Application number: 2024/93464	
What is the application for?:	Variation condition 2 (plans) on previous permission 2023/91483 for demolition o
Address of the site or building:	adj, 33a, Church Lane, Clayton West, Huddersfield, HD8 9LY
Postcode:	HD7 6NF

Drawing No CVD 01 - Proposed elevations and site plan.
 Proposed dwelling.
 Land adjacent 33a Church Lane, Clayton West HD8 9LY.
 Jan 2025.

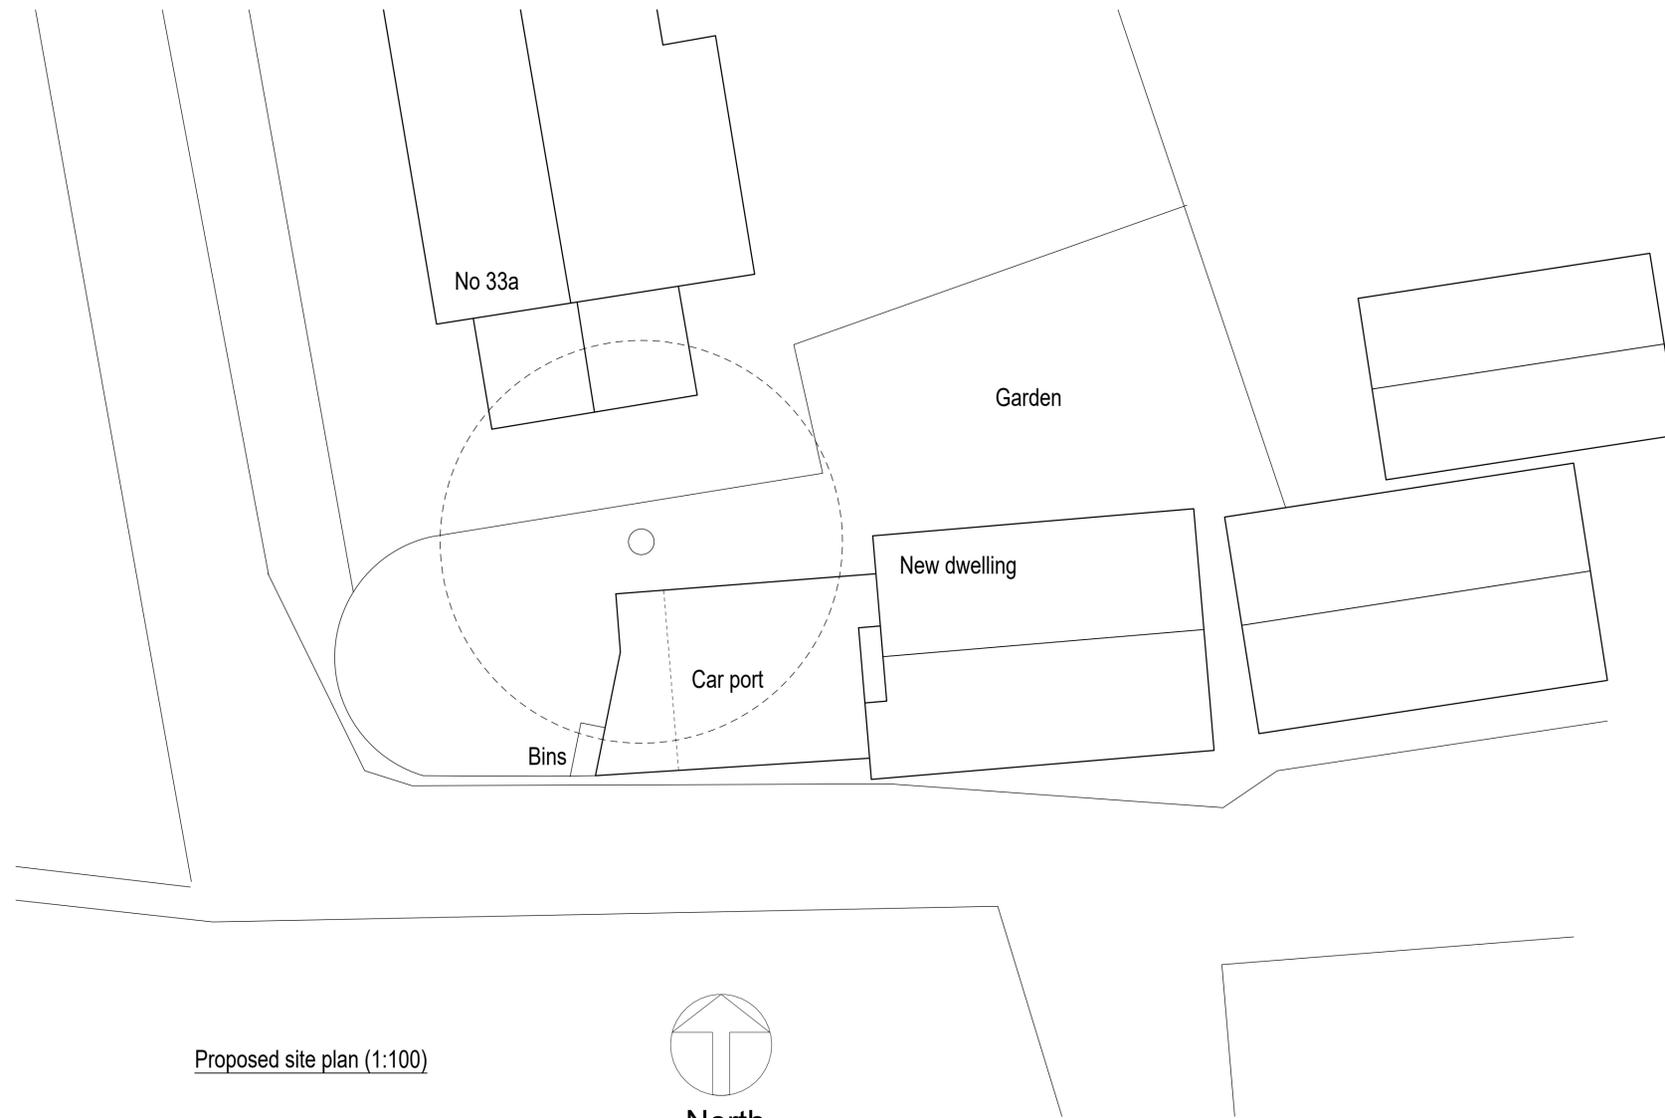
Type of comment: An objection	
Do you wish your comments to be published on the website anonymously?	Yes
I still fail to see how a car port facing the narrow lane is going to enable cars to get out onto the lane as there are always other cars parked there.
